Tel: 01903 737756
Email: planning@arun.gov.uk
www.arun.gov.uk/planning
Please ask for: Ms Ella Summerfield
Email: ella.summerfield@terraquest.co.uk
Telephone: 0121 2341390
Our Ref: CM/21/26/L
Your Ref:
Date: 23rd July 2026

Development: Replacement of existing windows (7 no. in total) plus 1 no. exterior door with identical style.

Location: Kents Farm House Brookpit Lane Climping BN17 5QU

Revisions	
A	Revisions
© copyright	
Client: T AND S JACKSON	
Job Title: KENTS FARM HOUSE CLIMPING WEST SUSSEX BN17 5OU	
Drawing Title: ELEVATIONS MAIN HOUSE PROPOSED	
1:50 @ A0	
D OCT 2020	Drawn by MJW
Drawn by	Rev.
112/168/5

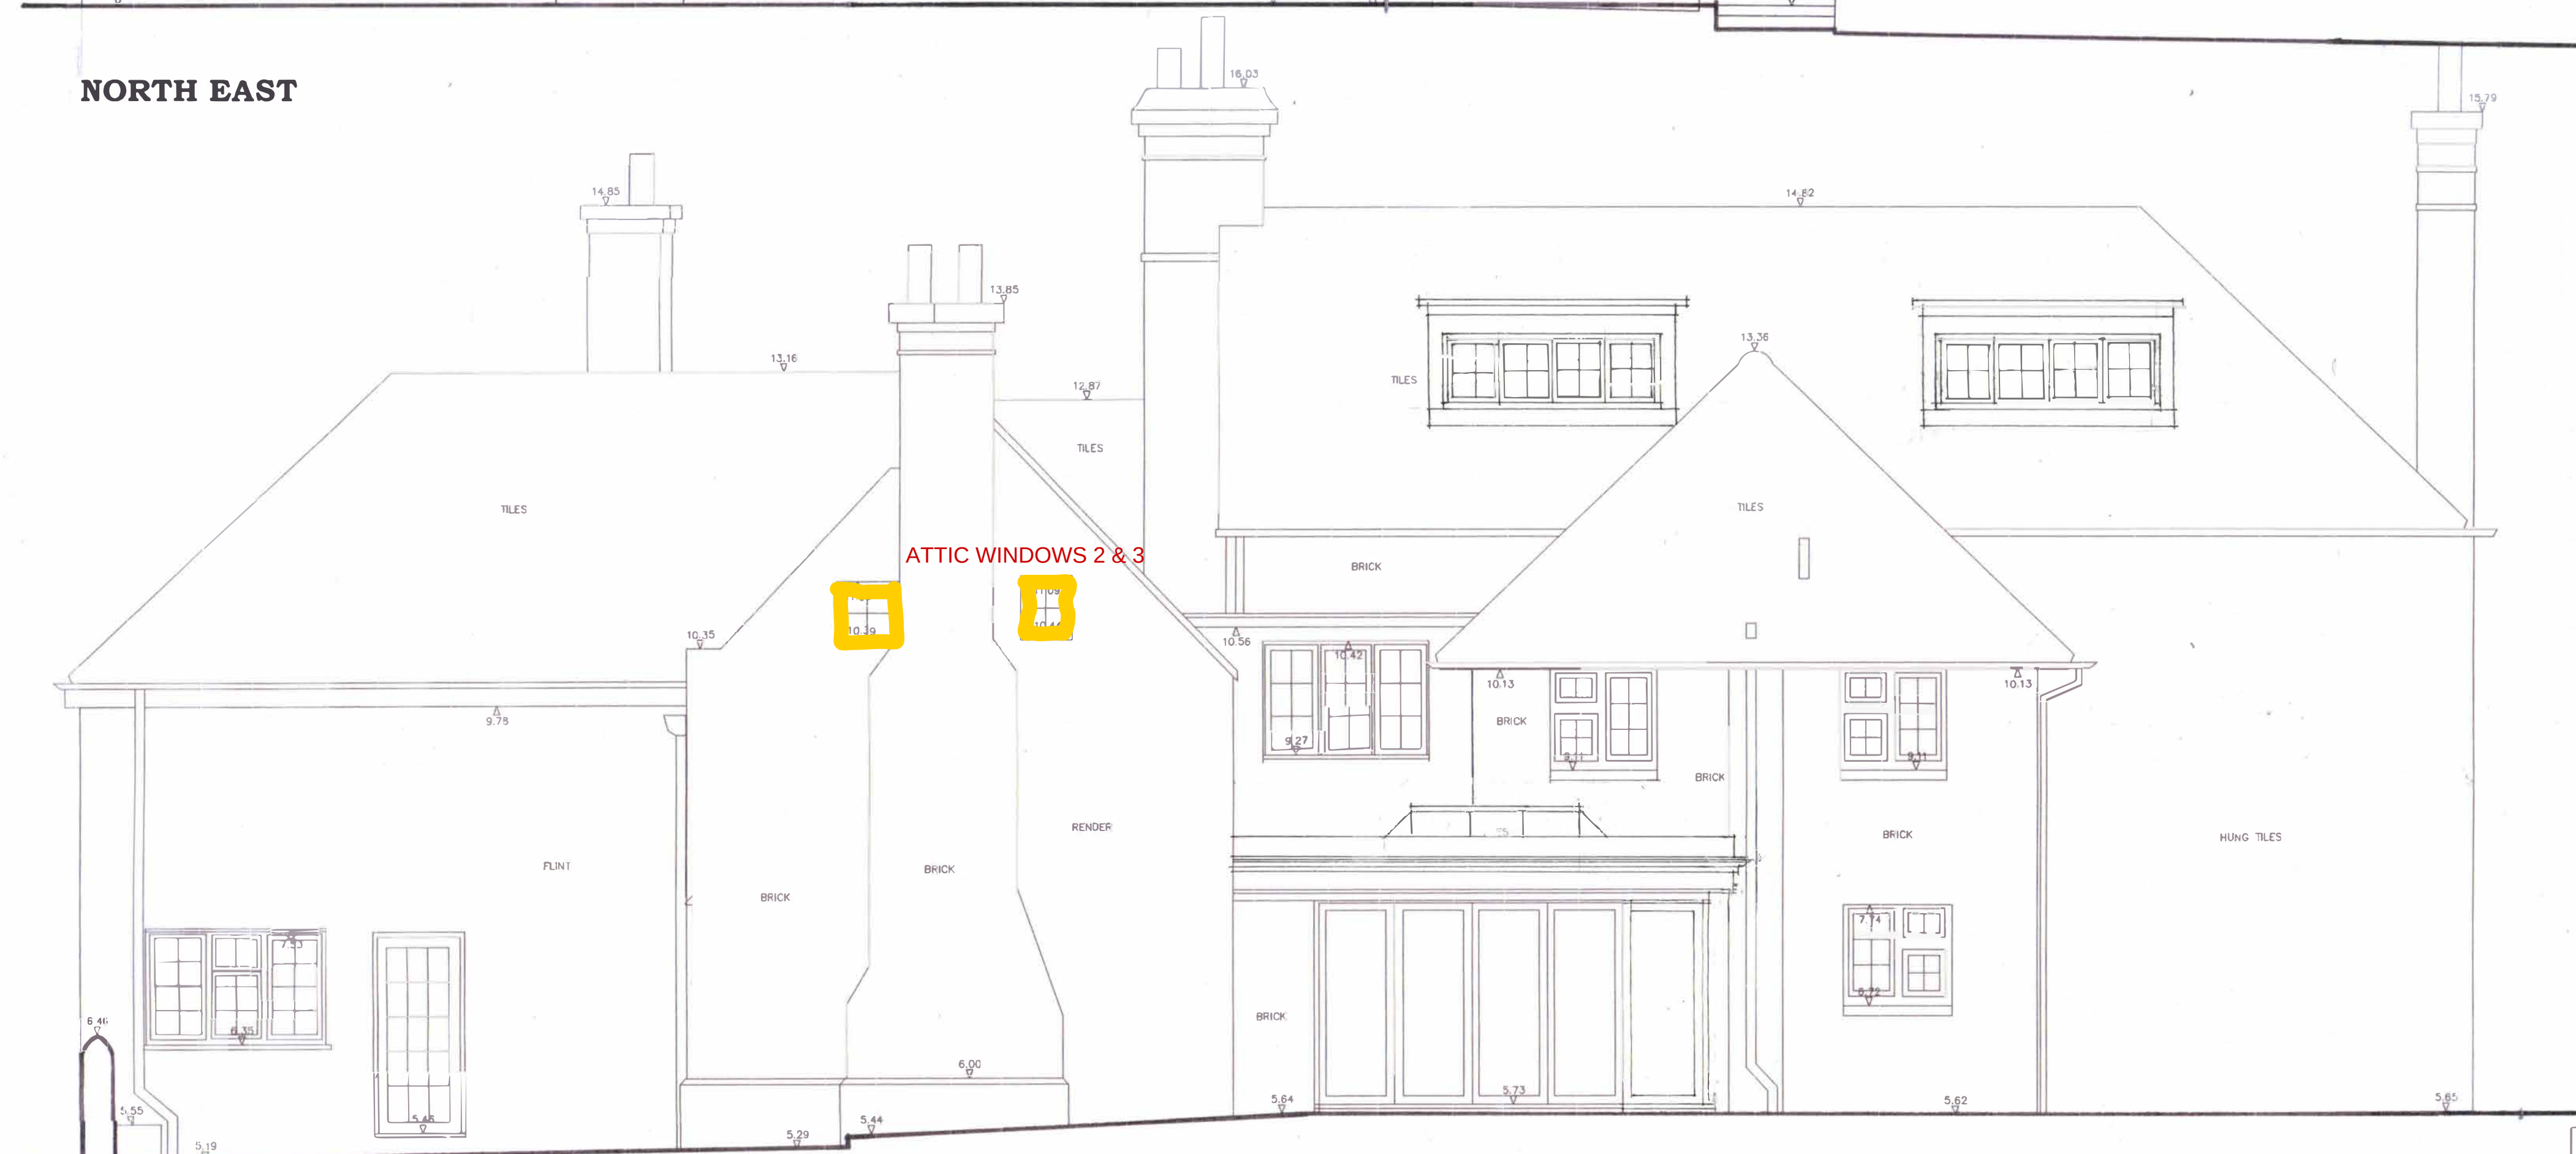
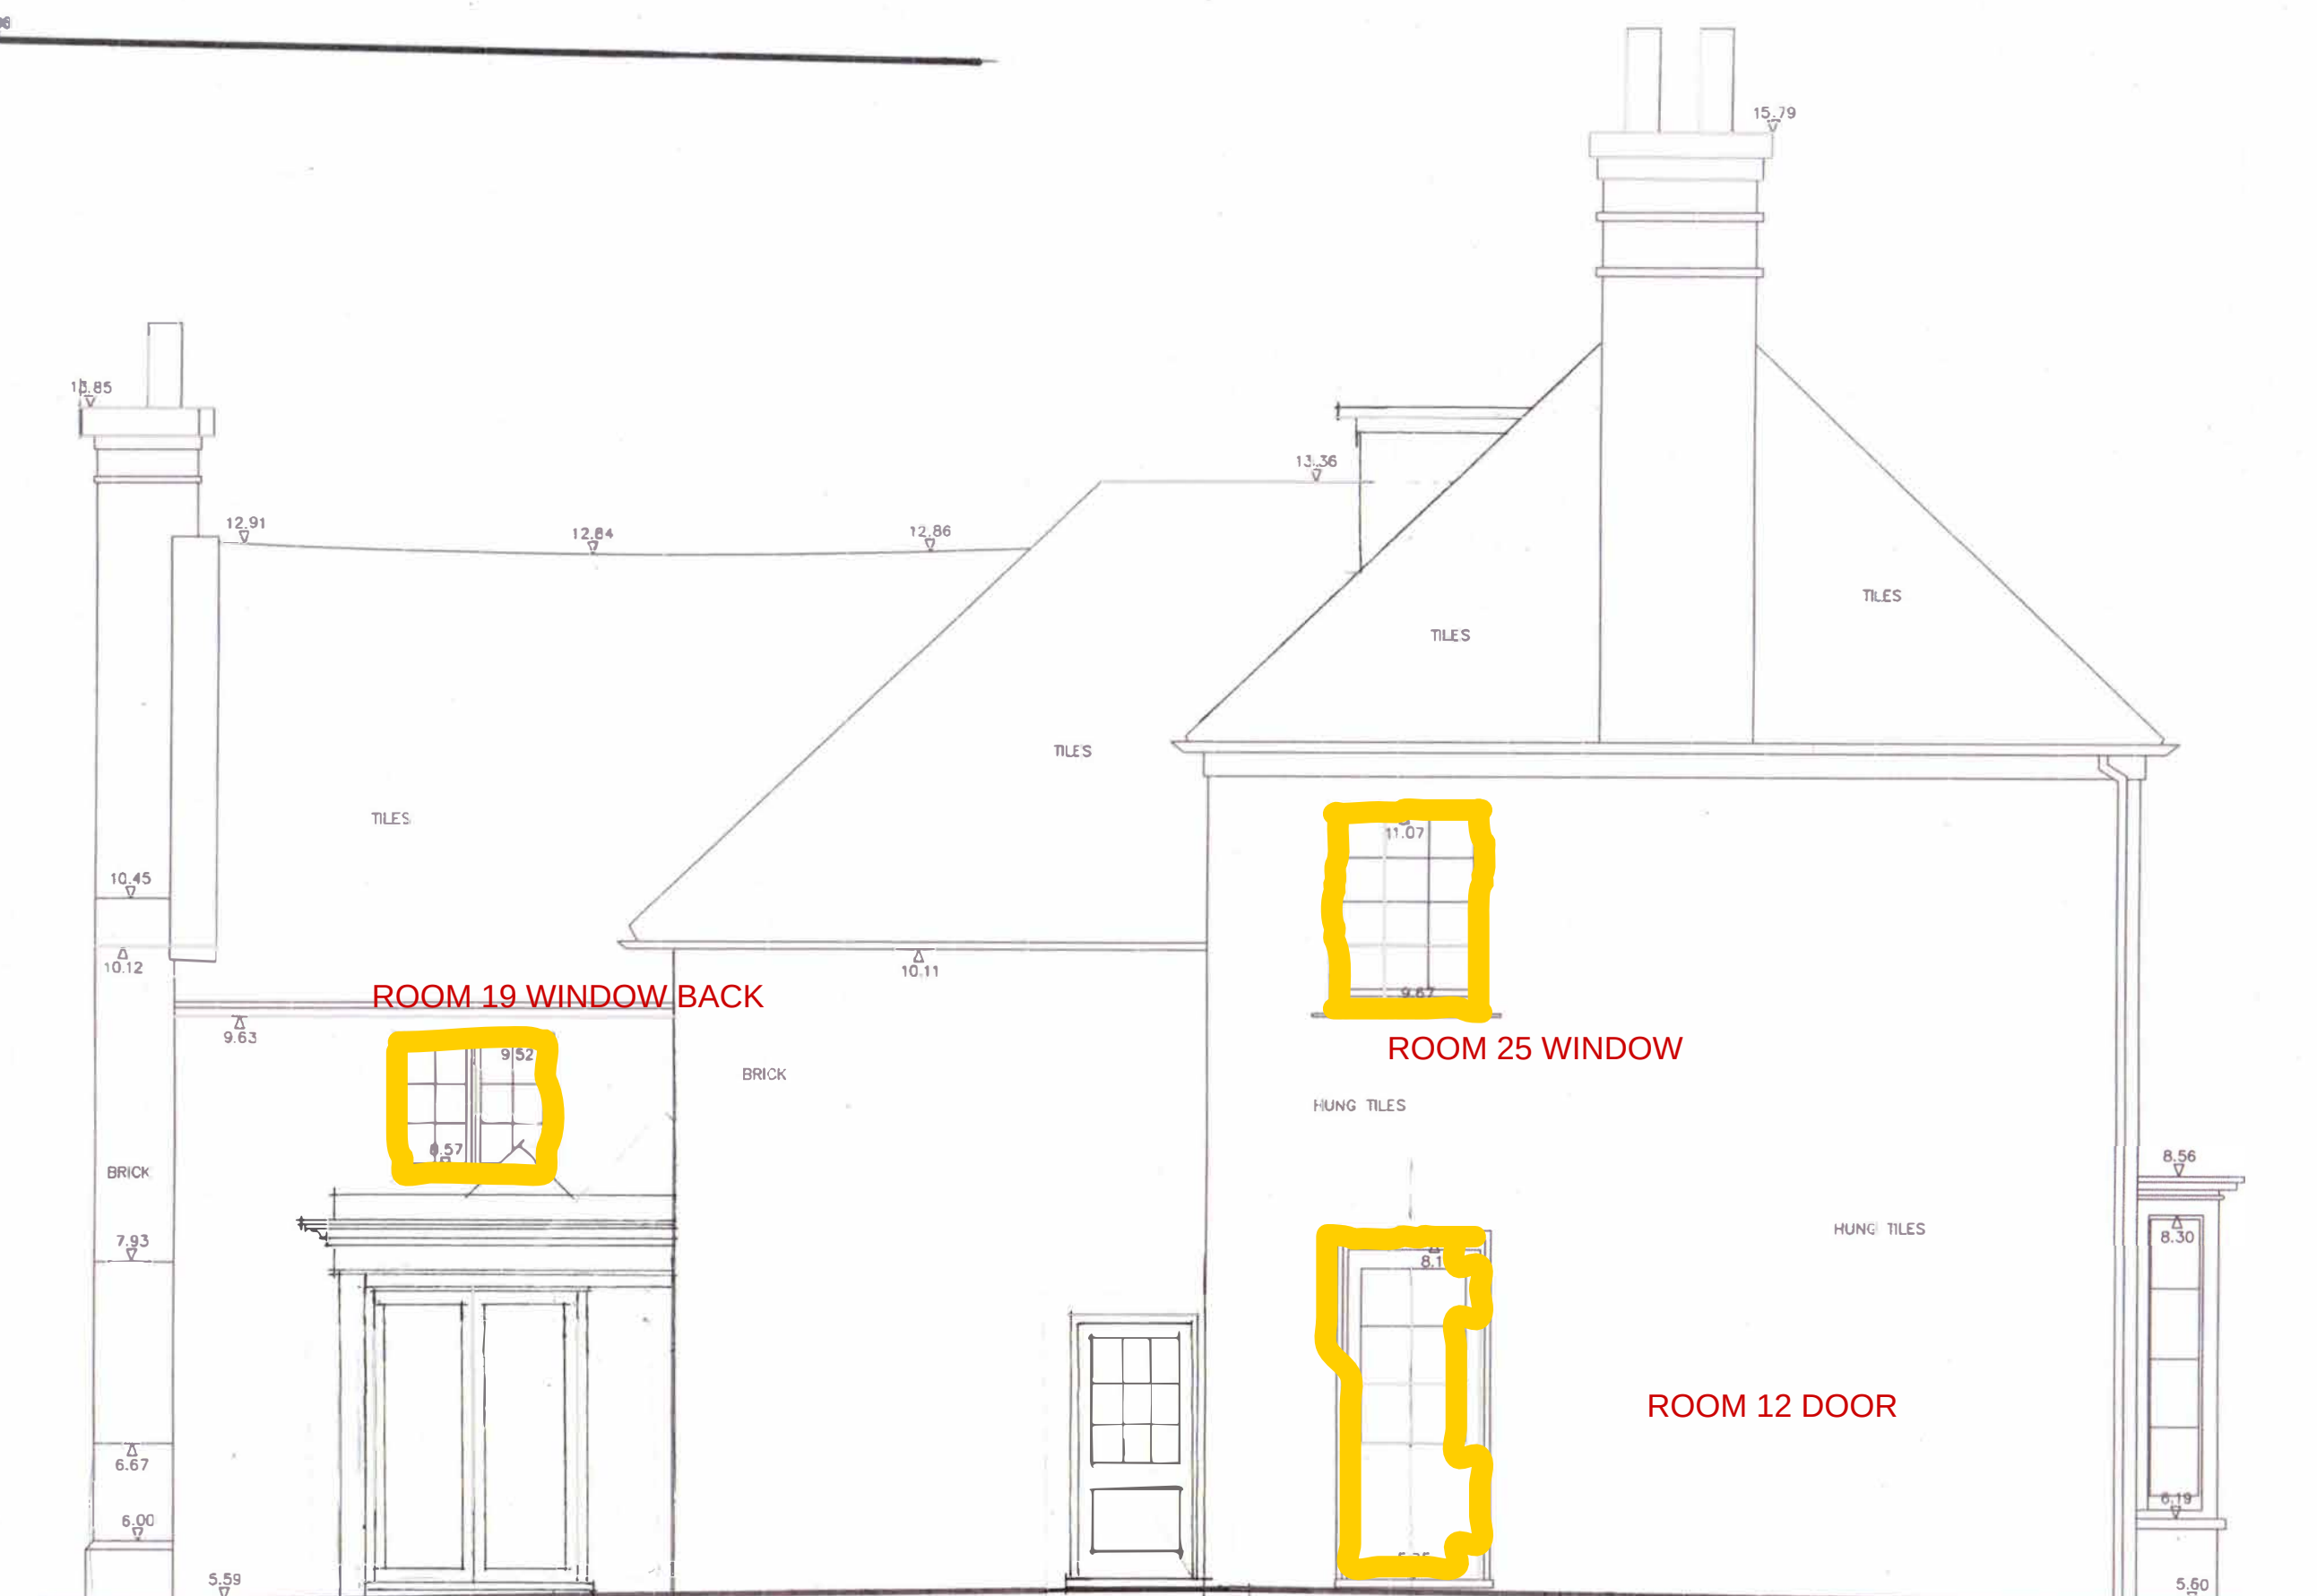
The proposed elevation plan scale bar appears to be inaccurate to the provided scale, please review.

When there are two scales provided the plan must clearly show which scale belongs to which drawing.

Please upload a scanned version of the proposed elevation plans in pdf format- The Proposed elevation plan provided is blurry.
